**DEVELOPMENT REVIEW BOARD - HYDROLOGY SECTION**

DRB Project Number: 2019-002184 Hearing Date: 1-29-20  
 Project: Guardian Storage Juan Tabo & Osuna Agenda Item No: 8

SHEET TITLE: CONCEPTUAL DRAINAGE PLAN

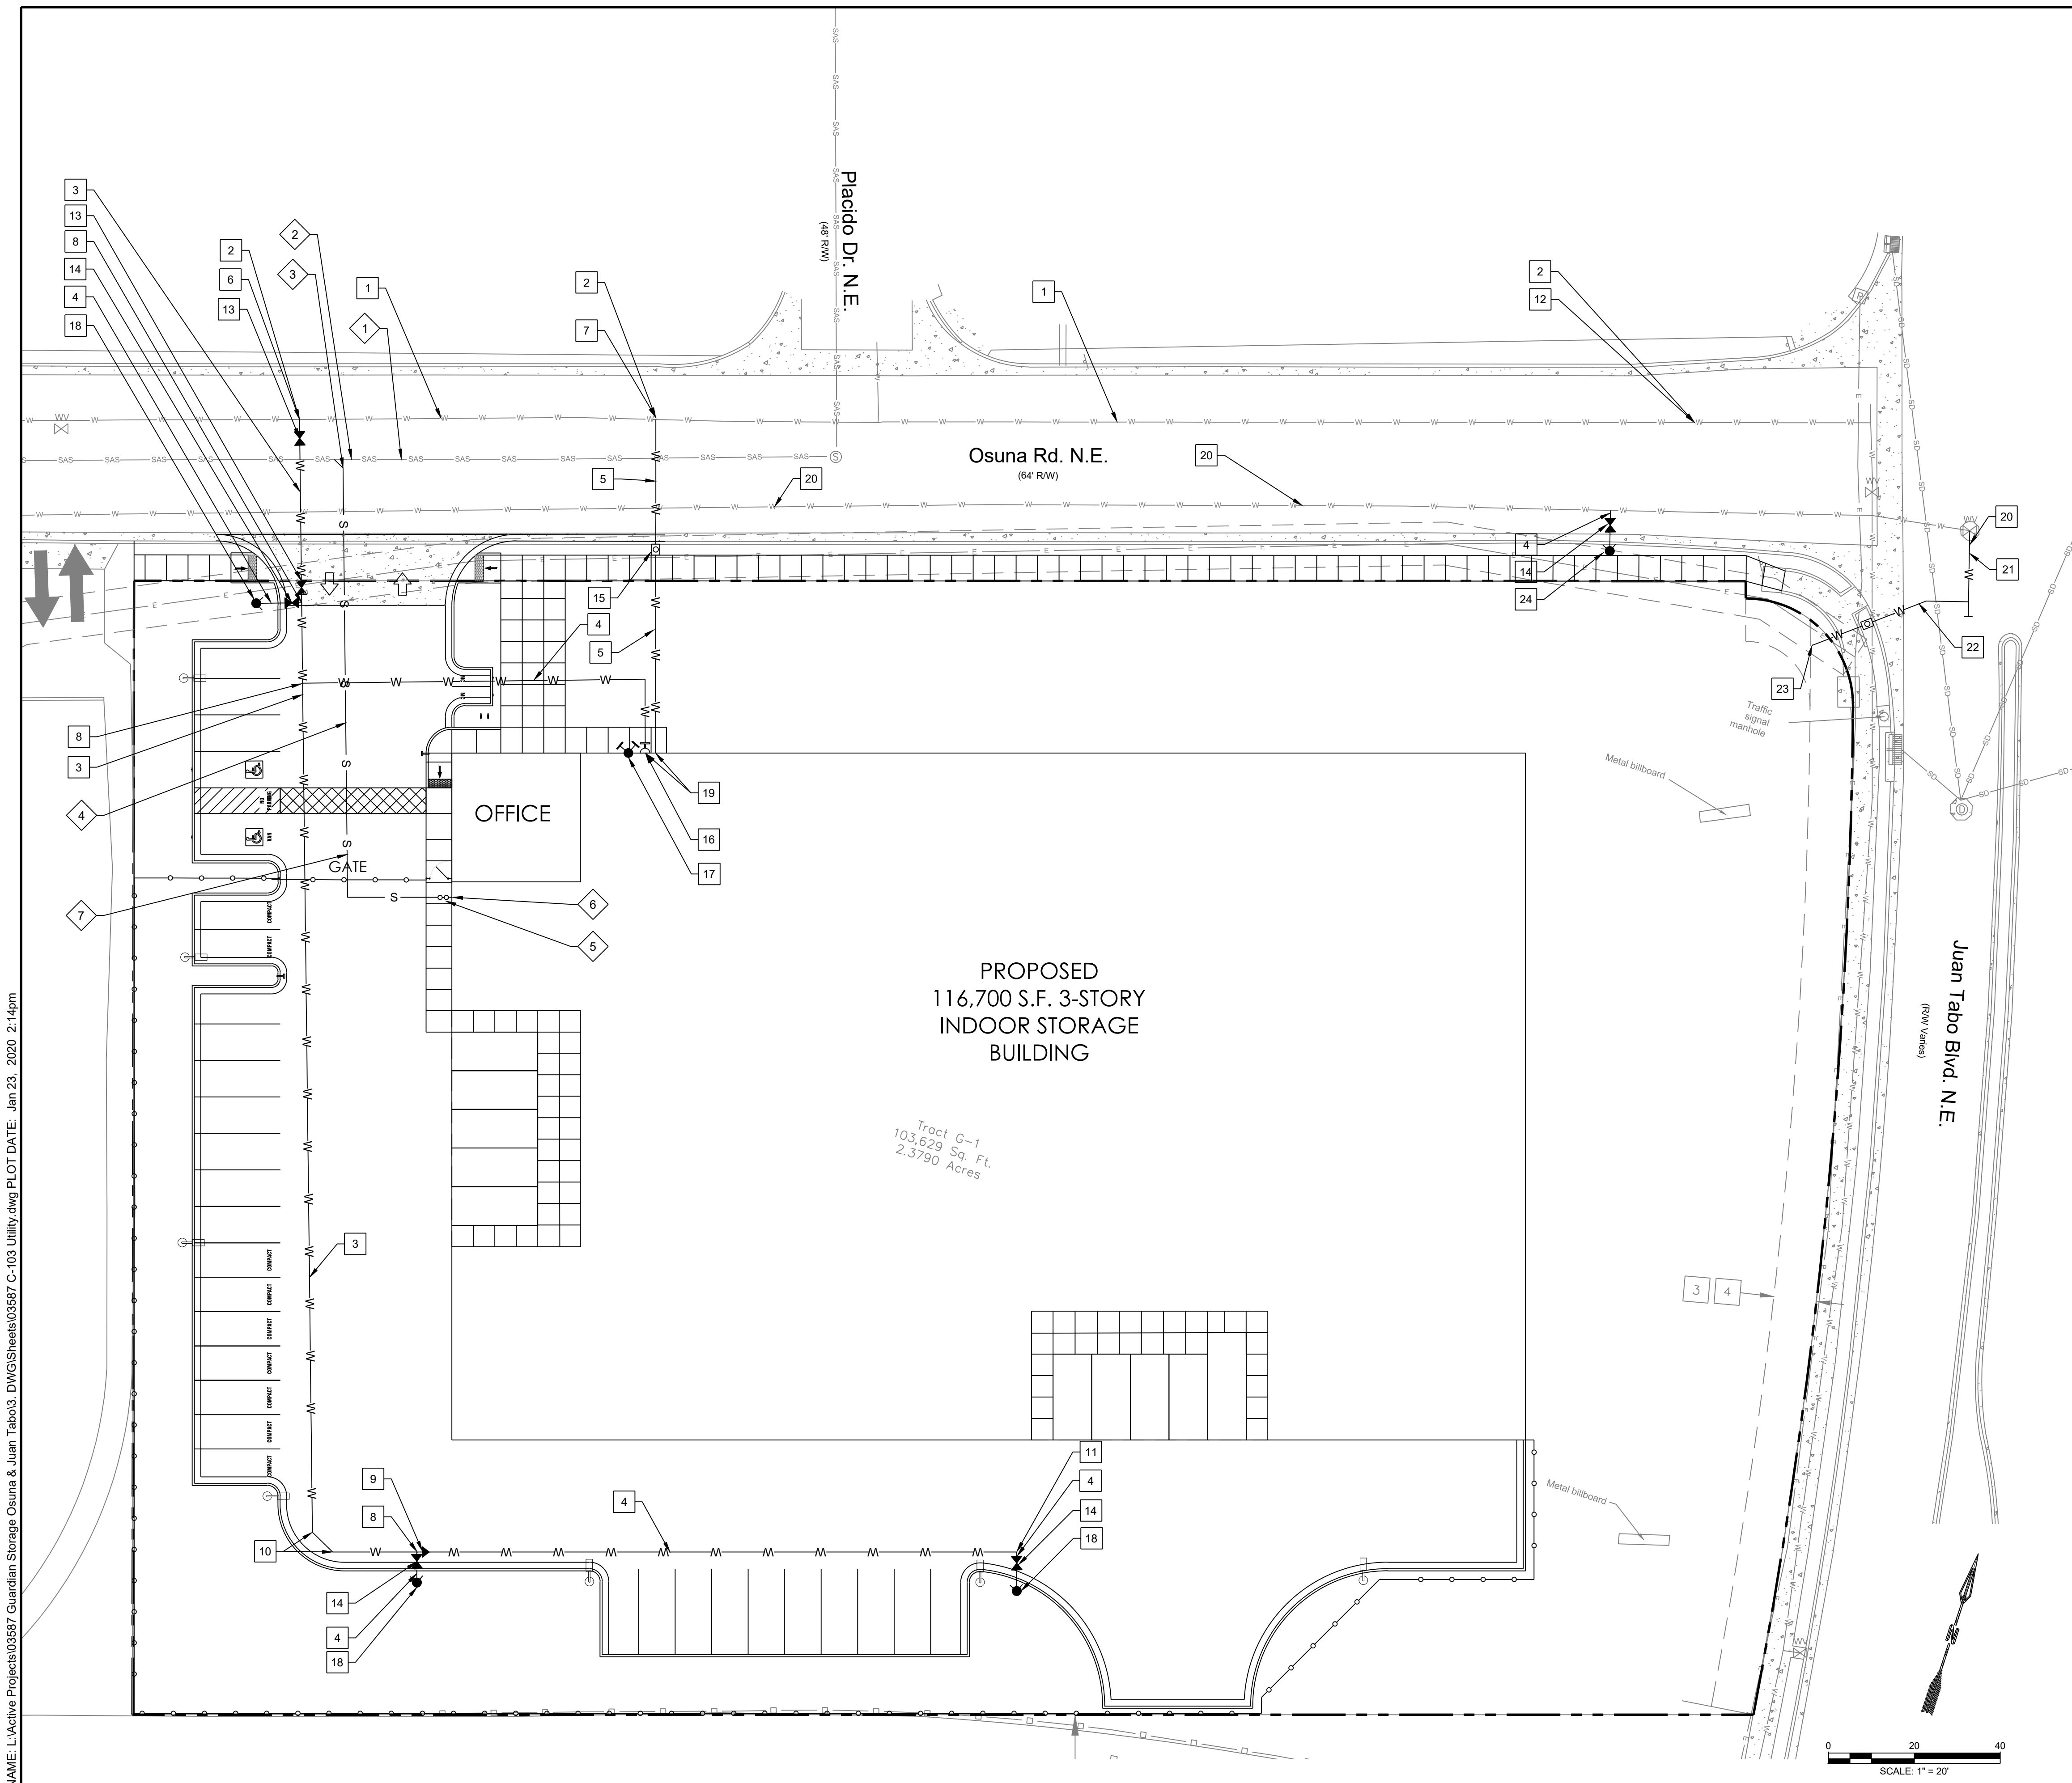
- Hydrology has an approved conceptual grading and drainage plan with Engineer's stamp dates: 12/20/19 & 1/9/20.
- This plan needs to be included in the Site Plan; if the plan has been modified since, than it will need to be resubmitted to Hydrology for re-approval.
- No objection to the infrastructure list.
- No objection to the plat.
